FROM: Ian Gledhill **TO:** Arun District Council
FAO: David Innes

SUBJECT: LU/201/16/RES - Approval of reserved matters following outline consent
LU/229/10/ for appearance, landscaping, layout & scale for 85 No. dwellings

Windroos Nursery, Worthing Road, Littlehampton, West Sussex, BN17 6LY

TITLE PROPOSED SITE PLAN - SHEET 2 OF 2

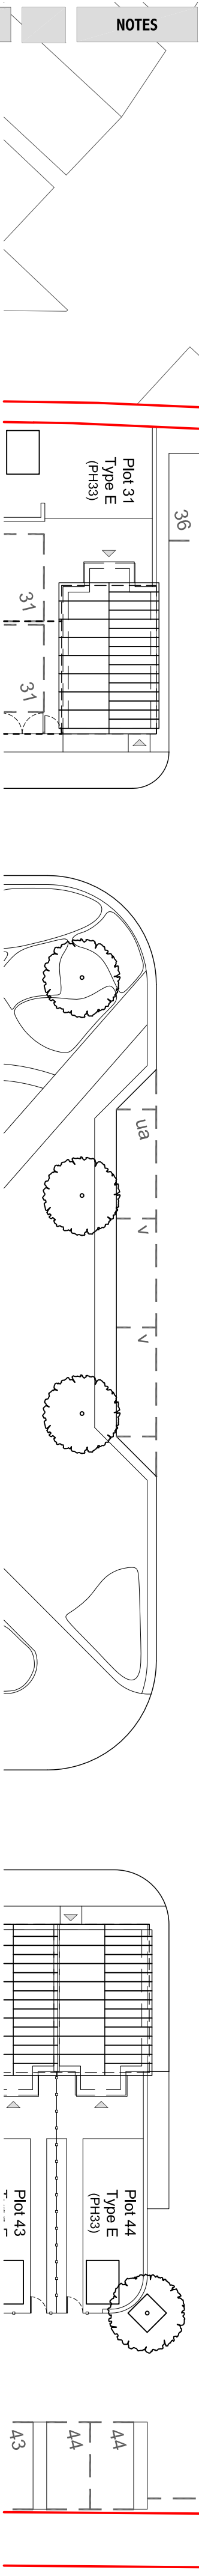
- It is recommended that the parking spaces north of plot 62 are located behind the footway instead of the layout as shown. This would make defining the extent of adoption more straightforward, i.e. it would be the back edge of the footway. Given that the exact extents of adoption are not clear, it may well be that this access road is not being offered for adoption.

- The kerb radii at the junction at the frontage of plot 63 should be enlarged as much as possible. The logic of the layout shown is acknowledged (that there is no through route from the proposed development into the adjoining completed development and as such there would be no reason for traffic to turn right). However the Design Brief for Site 7 (which incorporated both the adjacent completed and currently proposed development) envisaged a through route. Whilst there is a ransom strip between the two sites at present, this may be overcome. The design should be altered to reflect this.
